Our Ref: RDC 08M978 SYD10/00208
Contact: Stella Qu T 8849 2520
Your Ref: MP 08_0112

**7-9 GIBBONS STREET, REDFERN
MIXED USE – RESIDENTIAL/COMMERCIAL/RETAIL DEVELOPMENT**

I referred to the Department of Planning's correspondence received on 22 March 2010 (Reference MP08_0112), concerning the abovementioned Development Application which was referred to the Roads and Traffic Authority (RTA) for comment in accordance with Clause 104 of State Environmental Planning Policy (Infrastructure) 2007. I wish to advise that the Sydney Regional Development Advisory Committee (SRDAC) considered the traffic impact of this application at its meeting held on 8 April 2010.

01 BASEMENT LEVEL 6-3 FLOOR PLAN (RESIDENTIAL/COMMERCIAL)  
1:200

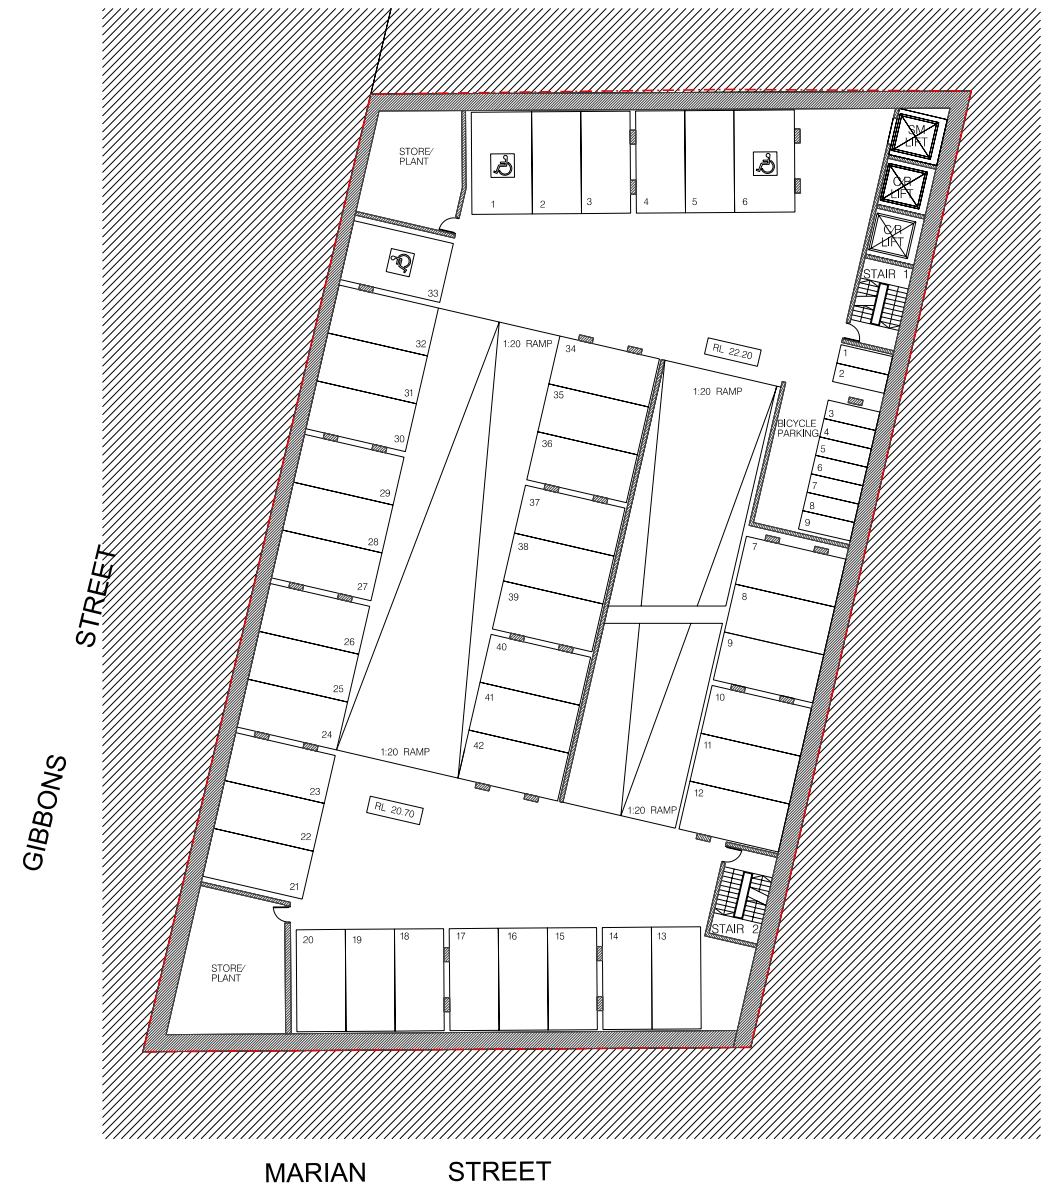
3. Existing No Stopping parking restrictions are to remain along the Gibbons Street frontage of the subject site.
4. It is noted that the proposed development will result in a loss of 76 off-street car parking spaces associated with the Lawson Square Towers, which is a 50% reduction. The proposed number of car parking spaces on the subject site shall be addressed to the satisfaction of the Department of Planning in consultation with the Council.

7. The layout of the proposed car parking areas associated with the subject development (including, driveways, grades, turn paths, sight distance requirements, aisle widths, aisle lengths, and parking bay dimensions) should be in accordance with AS 2890.1 – 2004, AS 2890.2 – 2002, and AS 2890.6 – 2009.
8. Retail parking should be separate from residential parking and should be clearly sign posted.
9. The internal aisle ways are to be marked with pavement arrows to direct traffic movements in / out of the site and guide traffic circulation through the car park.
10. The proposed turning areas within the car park are to be kept clear of any obstacles, including parked cars, at all times.
11. All vehicles are to enter and leave the site in a forward direction.
12. All vehicles should be wholly contained on site before being required to stop.
13. All loading and unloading shall occur on site.

01 GROUND FLOOR PLAN
1:200

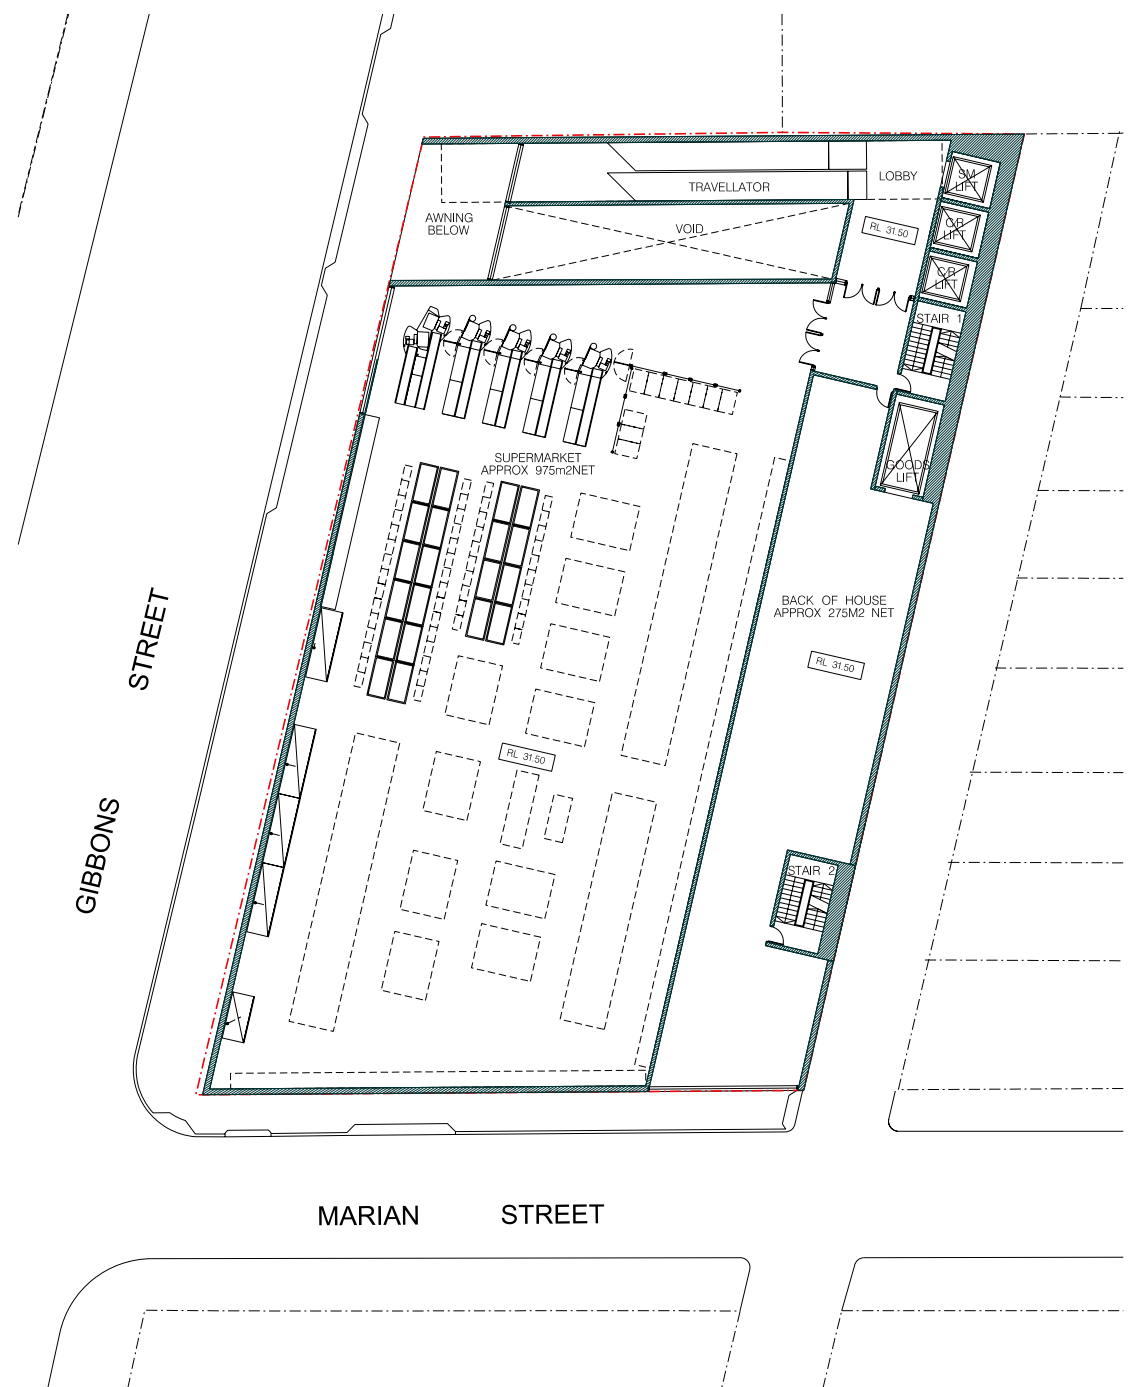
1. The traffic report submitted with the application states that the longest vehicle accessing the proposed loading dock is a 12.5 metre long heavy rigid vehicle. However, it is noted that 10.5 m HRV and 8.8 m MRV are used as design vehicles in the swept path analysis in the traffic report. Therefore, a modified swept path analysis of a 12.5 m long HRV should be submitted, prior to the determination of the development application.

In addition to the above, it is possible that delivery vehicles longer than 12.5 metres will deliver goods to the proposed supermarket as these delivery vehicles are likely to do multiple deliveries in one trip. Therefore, the developer needs to satisfactorily demonstrate to the Department of Planning and the RTA that the supermarket can deliver all goods with a truck no longer than 12.5 metres in length.

2. No Stopping parking restrictions shall be provided along the Marian Street frontage of the subject site between William Lane and Gibbon Street as deliver vehicles are likely to park on the Marian Street frontage of the subject site, which will affect traffic flow and driver's sight distance at the

15. AS 2890.1 - 2004, Clause 3.3 (a) for property line / building alignment / pedestrian path, permits a maximum gradient of 1 in 20 (5%) between edge of frontage road and the property line, building alignment or pedestrian path for at least the first 6 metres into the car park. Council should ensure that the gradients provided for the development complies with AS 2890.1 - 2004.

16. Clear sight lines shall be provided at the property boundary line to ensure adequate visibility between vehicles leaving the car park and pedestrians along the frontage road footpath in accordance with Figure 3.3 of AS 2890.1 - 2004 for light vehicles and AS 2890.2 - 2002 for heavy vehicles.
